Great Lakes UK Limited
Great Wolf Lodge, Chesterton, Bicester

Non Material Amendment (S.96a) Application
Design Changes

March 2023

This document has been prepared by EPR Architects in support of a Non Material Amendment (NMA) application associated with proposed changes to Applicant ref. 21/04158/F.

Proposed Roof Plan Part 7

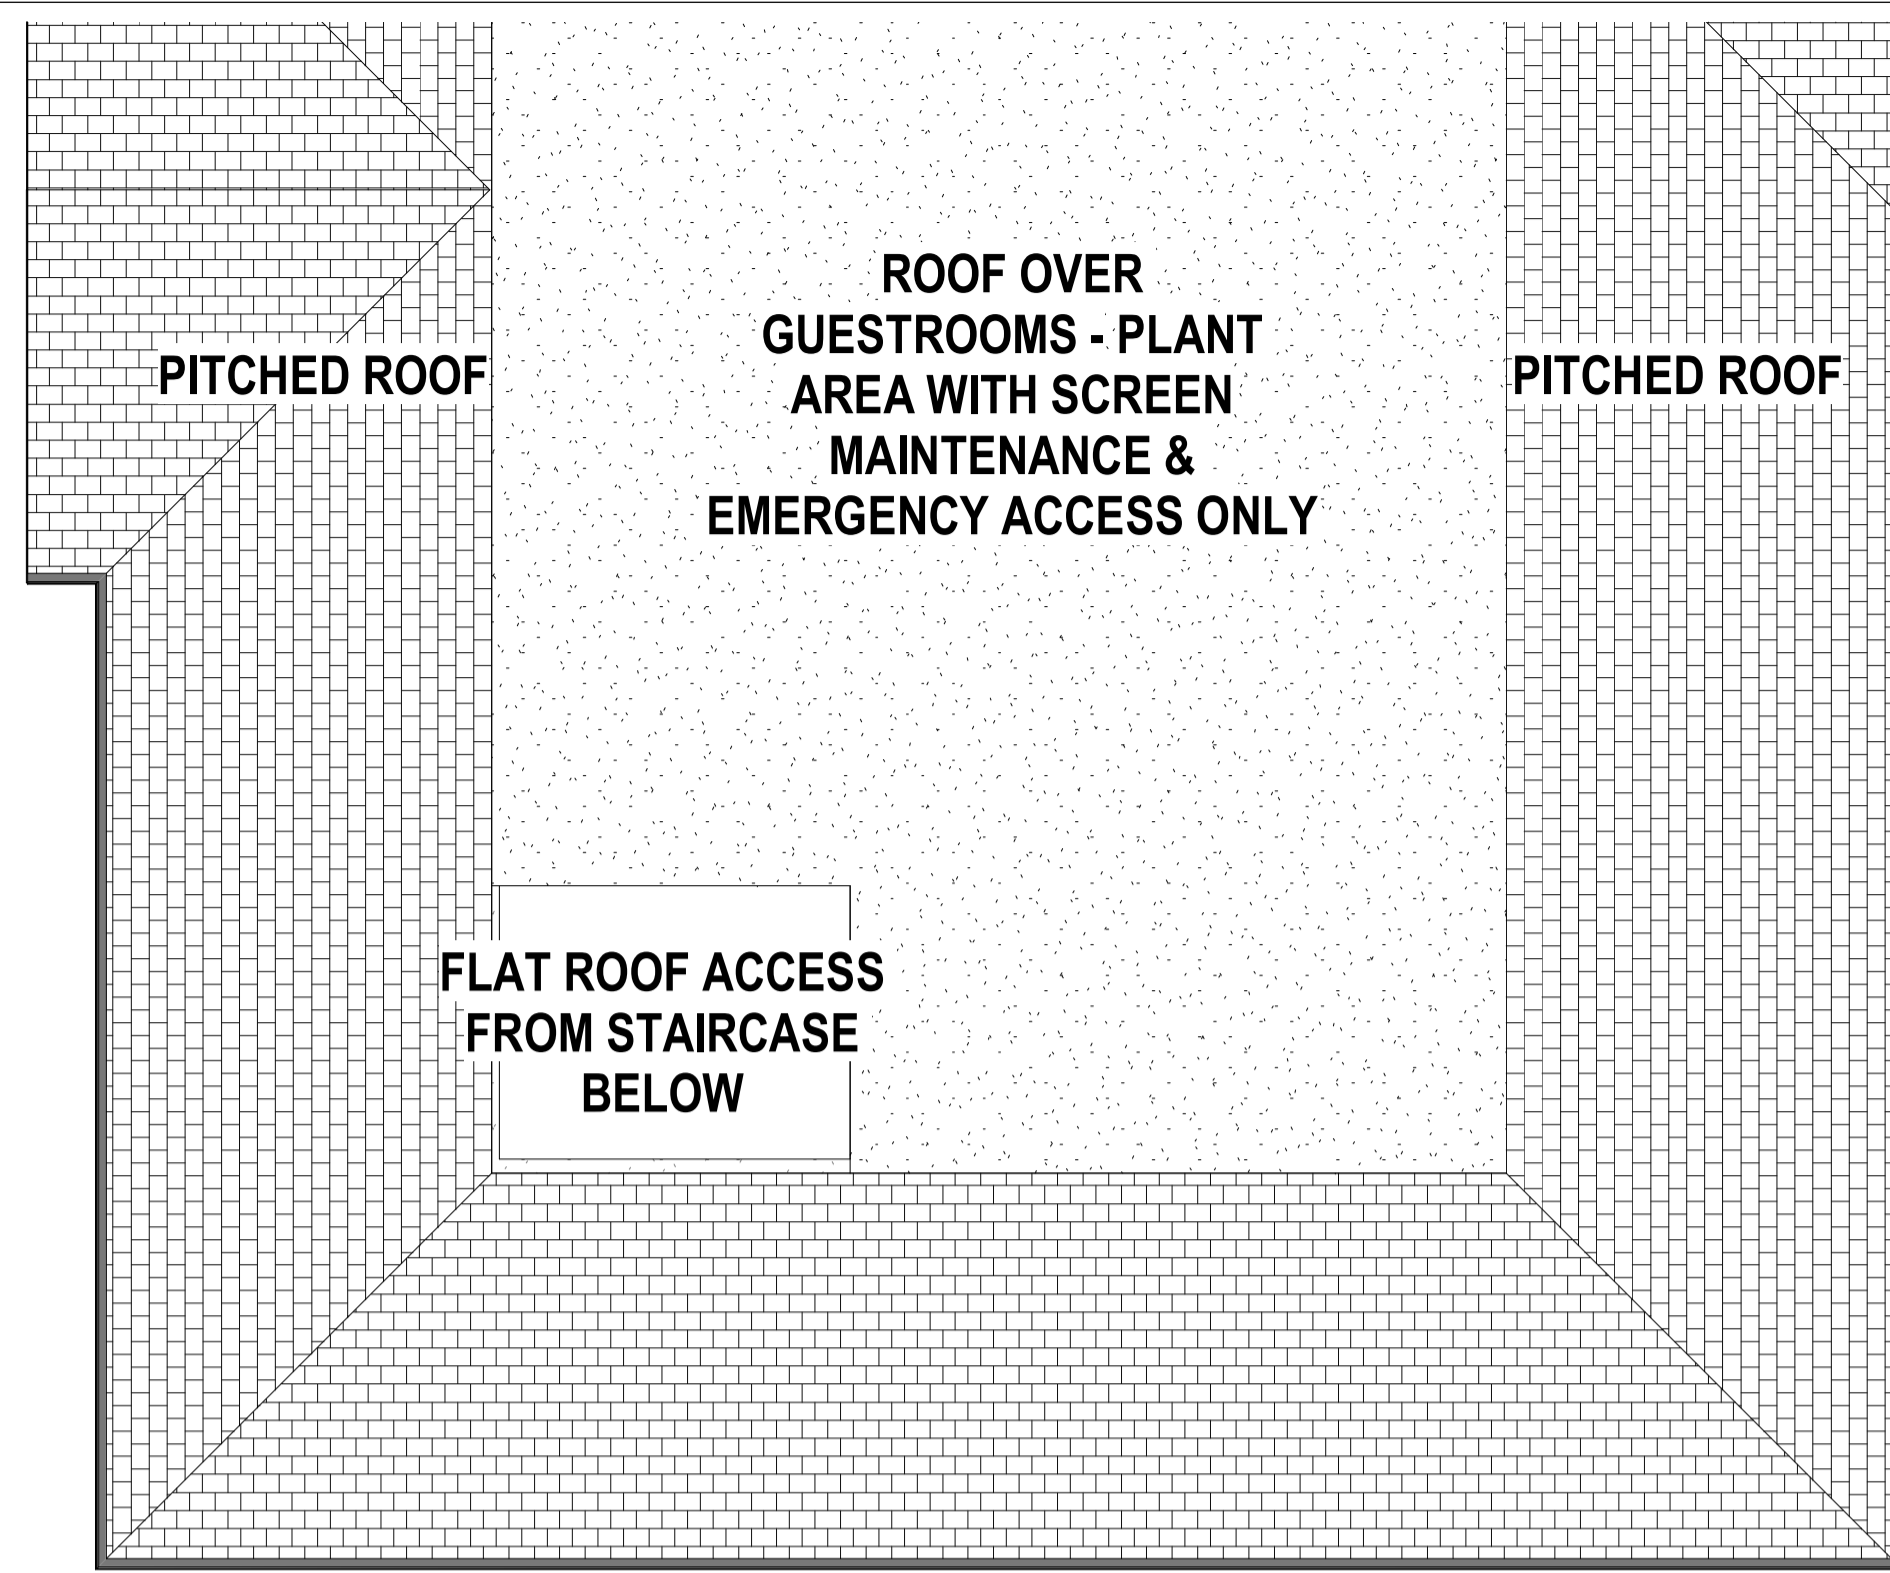
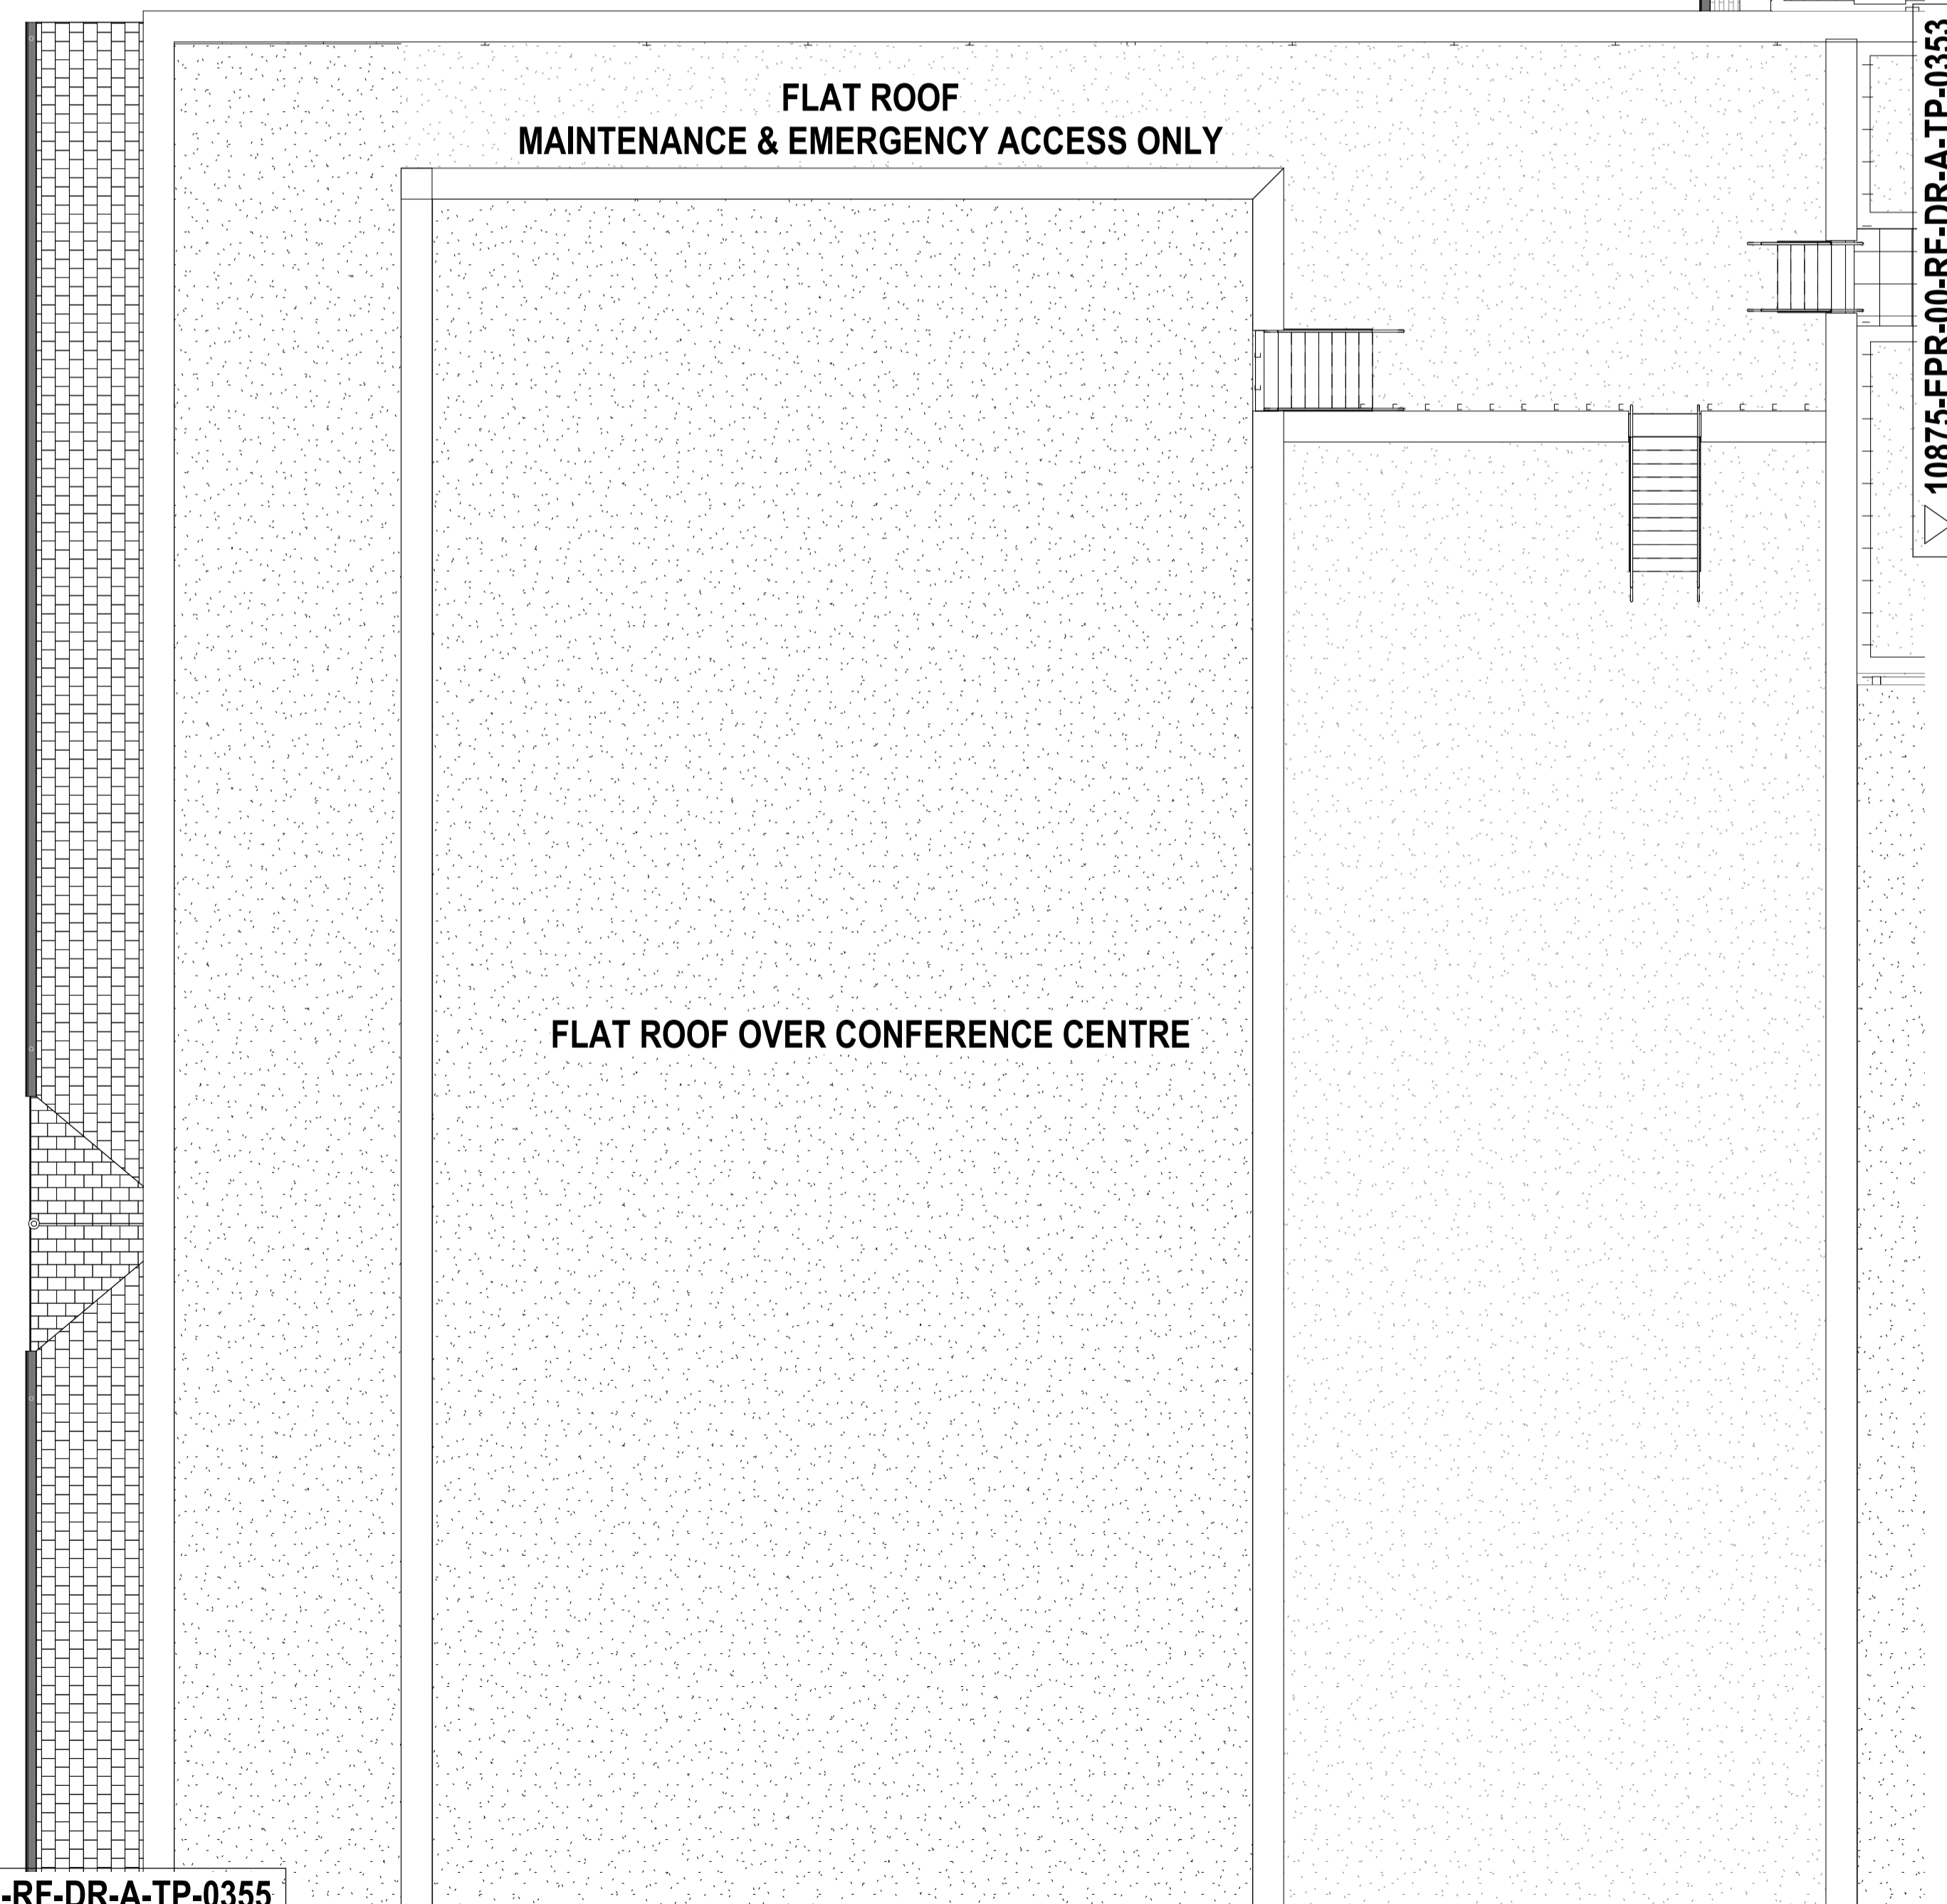
- ① Parapet wall created to roof of FEC roof to provide positive edge to waterpark roof for good roofing design practice and waterproofing.
- ② Bunker roof now extends in to the waterpark roof as a dormer.

- ③ Update to roof of the FEC to conference centre. Parapet wall pushed towards the conference centre side.
- ④ Parapet line moved left to move steels out of the party room.

- ⑤ Rain water pipes moved on NE and NW elevations.
- ⑥ Flue on green roof and louvres on wall facing service yard omitted.
- ⑦ Roof above hotel lobby dropped by approx. 990mm as a result of building design efficiency.

- ⑧ Louvred pop up on the roof over the laundry room added for ventilation purposes
- ⑨ Minor changes to balustrade / railing design and stair locations.

- ⑩ Chimneys removed.
- ⑪ Stair overruns removed and replaced with hatches and ladder access to the roof.
- ⑫ Access steps moved.
- ⑬ Small increase in height to Porte Cochere roof.

Proposed First Floor Plan Part 7

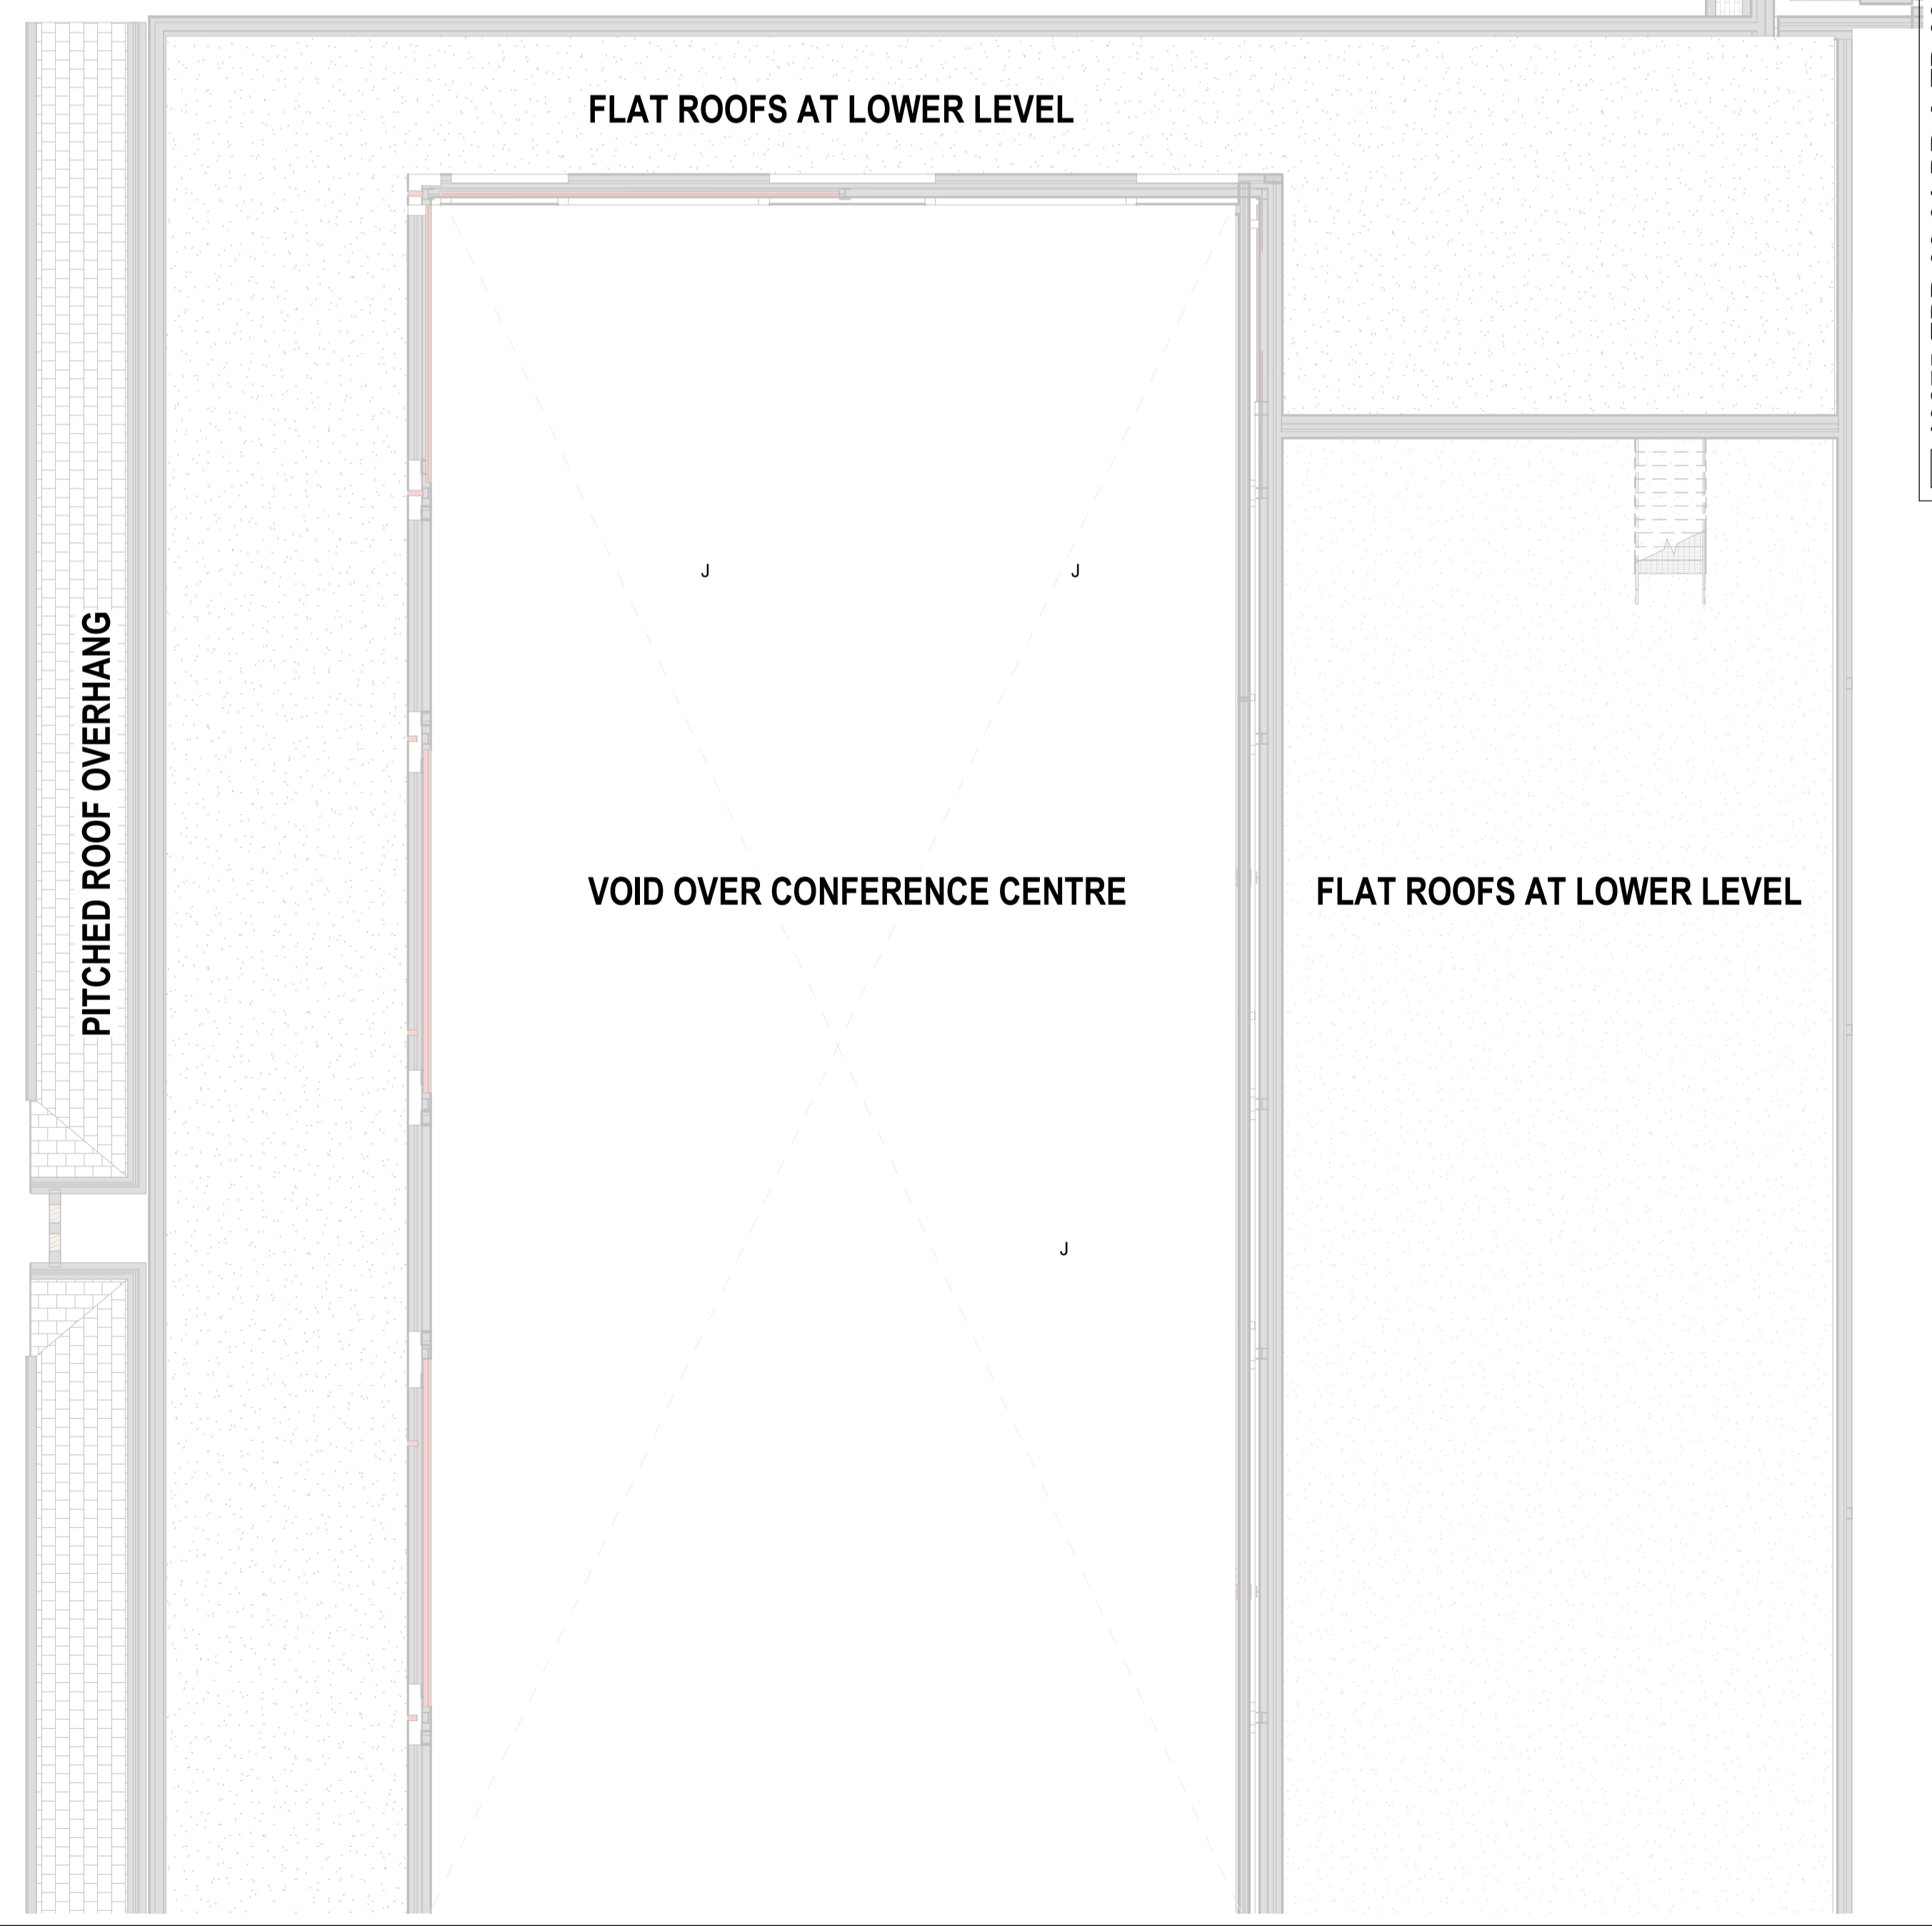
- ① Facades pushed out to allow columns not to protrude into guestrooms.
- ② Corner guestrooms changed to new enlarged types on every floor. 12 no. total rooms affected but no increase in room numbers with this change and no facade changes.
- ③ Façade wall moved down 100mm to align with equivalent wall on left hand side.
- ④ 2x Windows added on levels 1-3 and door added on right on level 1 to provide safer roof access
- ⑤ 6 No. total additional keys added where shown on levels 1-3. Total guestroom count to be 504.
- ⑥ Replace windows in corner rooms (where there were two windows in room) to recessed reveal detail.
- ⑦ Window types on the east side updated to match those on west side.
- ⑧ Additional means of escape off the roof via the 1st floor offices.
